## Heritage Interpretation | Strong Room - Updated Interpretation | The Lands SSD7484 - MOD 21

Freeman Ryan Design (FRD) has been engaged to provide Heritage Interpretation in the Lands by Capella Building.

Following submission of the documentation prepared to satisfy Condition F30, HNSW raised additional queries on the text as follows:

Level 1 Panel 2.2 – Shelves of Steel

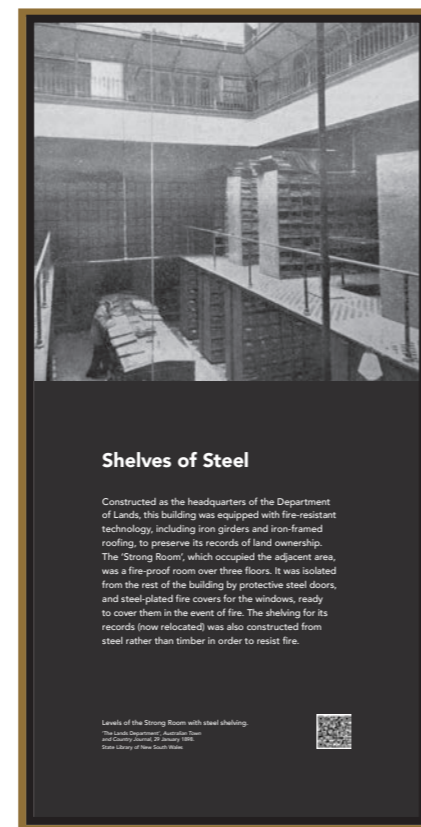
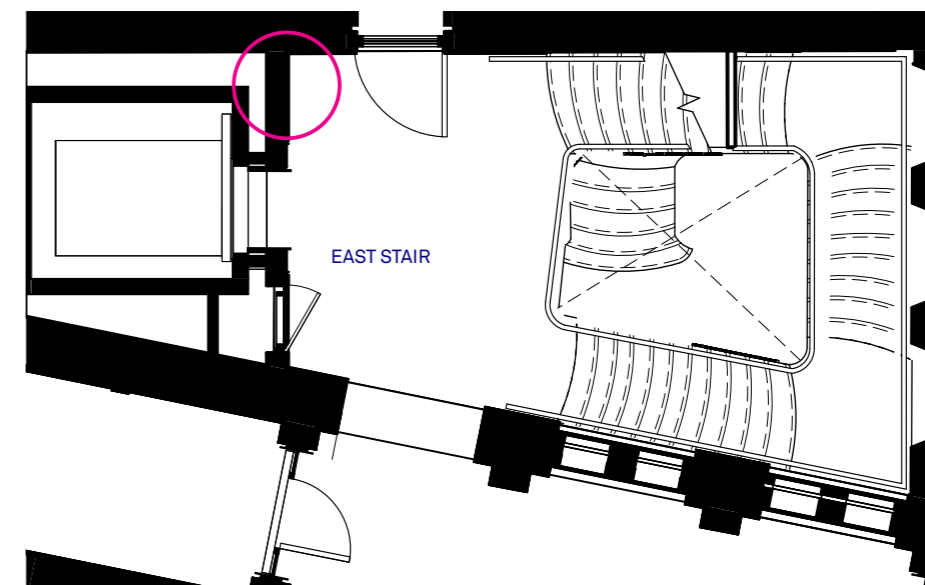
- Level 1 Panel 2.2 – the text should reflect that some of the strong room shelving has been retained in-situ (as required by consent condition C26).
- Generally the text should be clear that the strong room remains spatially intact and that the text is not referring to a feature that has been removed. Will the space continue to be known as the strong room?
- Highlight the umbrella mechanism as a unique feature to this building.
- Include a clearer description of the operation of the umbrella mechanism, which allowed the internal copper dome to be raised or lowered. ‘Retracted’ and ‘closed’ don’t adequately describe how it worked. Illustrations of the internal dome in open and closed positions would help to describe the feature.
- Check all descriptions of the Strong Room and its features for accuracy.

FRD has reviewed the text and have made amendments to the text and added diagrams in response to the comments, which is outlined below. This will be added to the Heritage Website as there is insufficient room on the panels.

The building included a 'Strong Room', a fire-proof, domed room spanning three floors in its centre, which has been retained spatially intact as a multi-level, open volume. It was especially designed for the safe-keeping of the documents with steel used for the doors and shelving (some of which remains in place), and steel-plated covers for the windows, ready to cover them in the event of fire.
